Application Ref:		3/2025/0279		 <div>Ribble Valley Borough Council</div> <hr/> www.ribblevalley.gov.uk
Date Inspected:	N/A	Site Notice:	N/A	
Officer:	EP			
DELEGATED ITEM FILE REPORT:				REFUSED

Development Description:	Certificate of Lawful Development for proposed single-storey extension to rear.
Site Address/Location:	3 Fennel Gate, Whalley BB7 9GQ.

SITE ADDRESS: 3 FENNEL GATE, WHALLEY BB7 9GQ

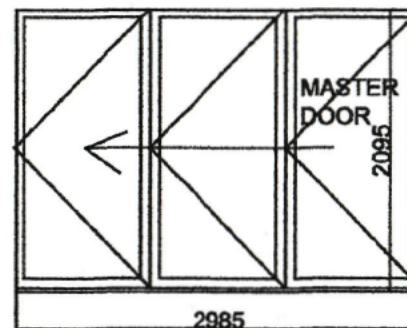
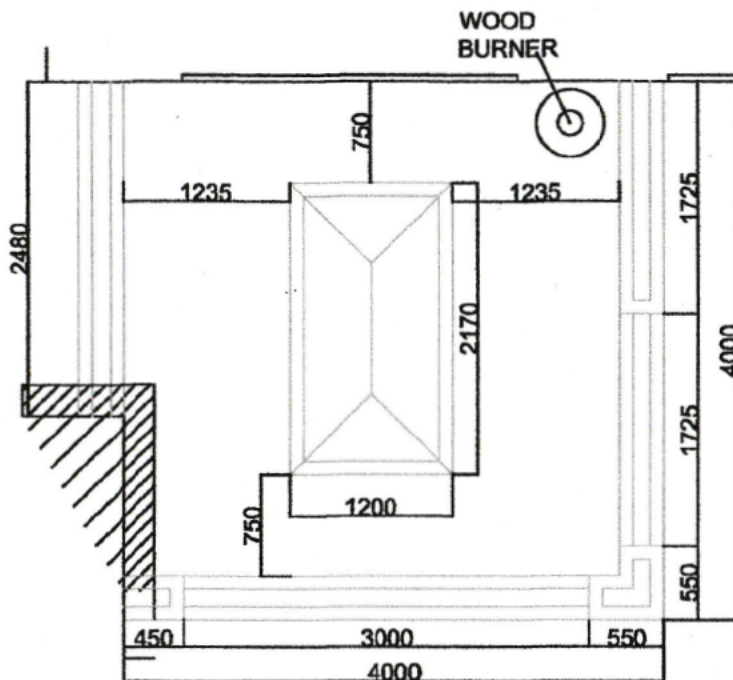
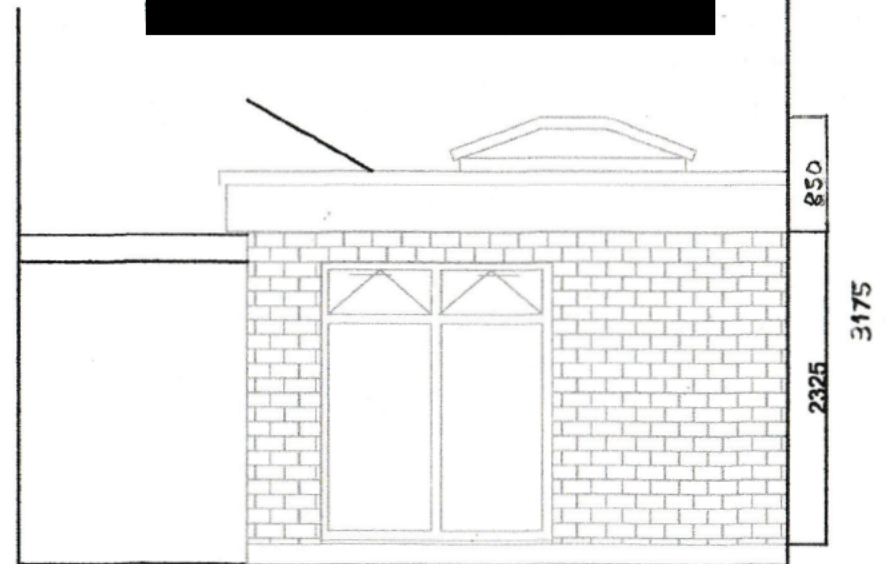
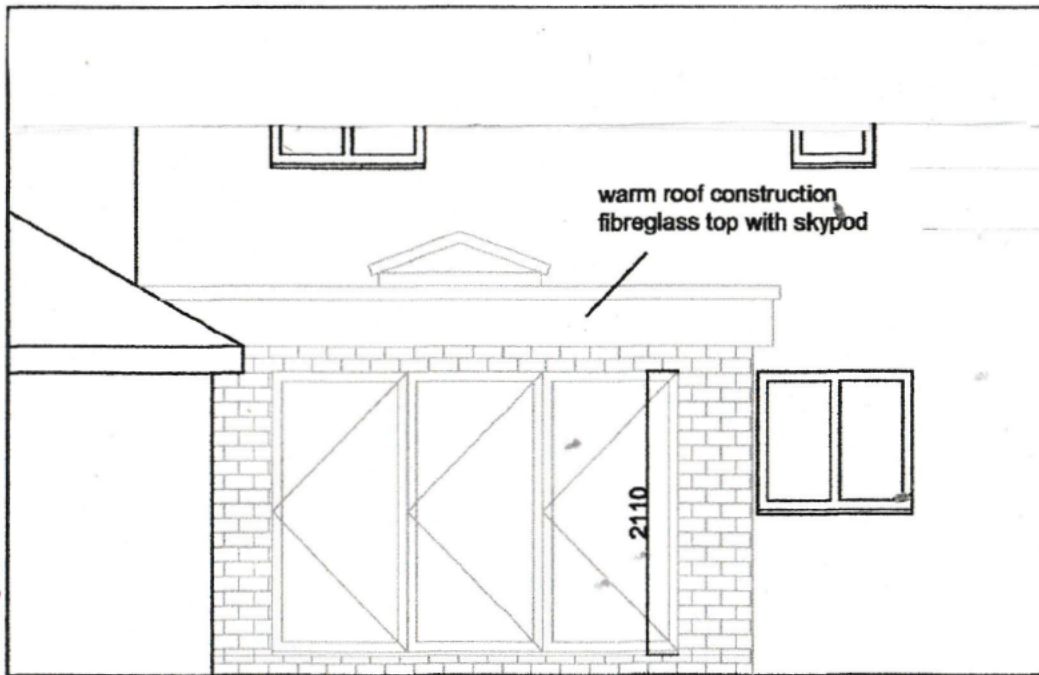
The proposed single storey extension, as per the submitted plans, will adjoin the existing detached garage structure. Given the proposed extension itself will have length of 4m, once combined with the length of the garage building, the overall length will exceed the allowed 4m.

The proposed single storey extension will adjoin the existing garage structure and will therefore have a sideways projection. Limited plans have been provided, however, desktop analysis suggests that the existing dwelling is approximately 7m in width. As a result, the width of the development as whole (proposed extension and adjoined garage) will exceed half the width of the original dwelling.

The proposed works do not constitute permitted development under The Town and Country Planning (General Permitted Development) (England) Order 2015 Schedule 2, Part 1, Class A as the proposed development at its longest point will measure greater than 4 metres from the rear elevation of the original dwellinghouse with a sideways projection that is greater than half the width of the existing dwellinghouse.
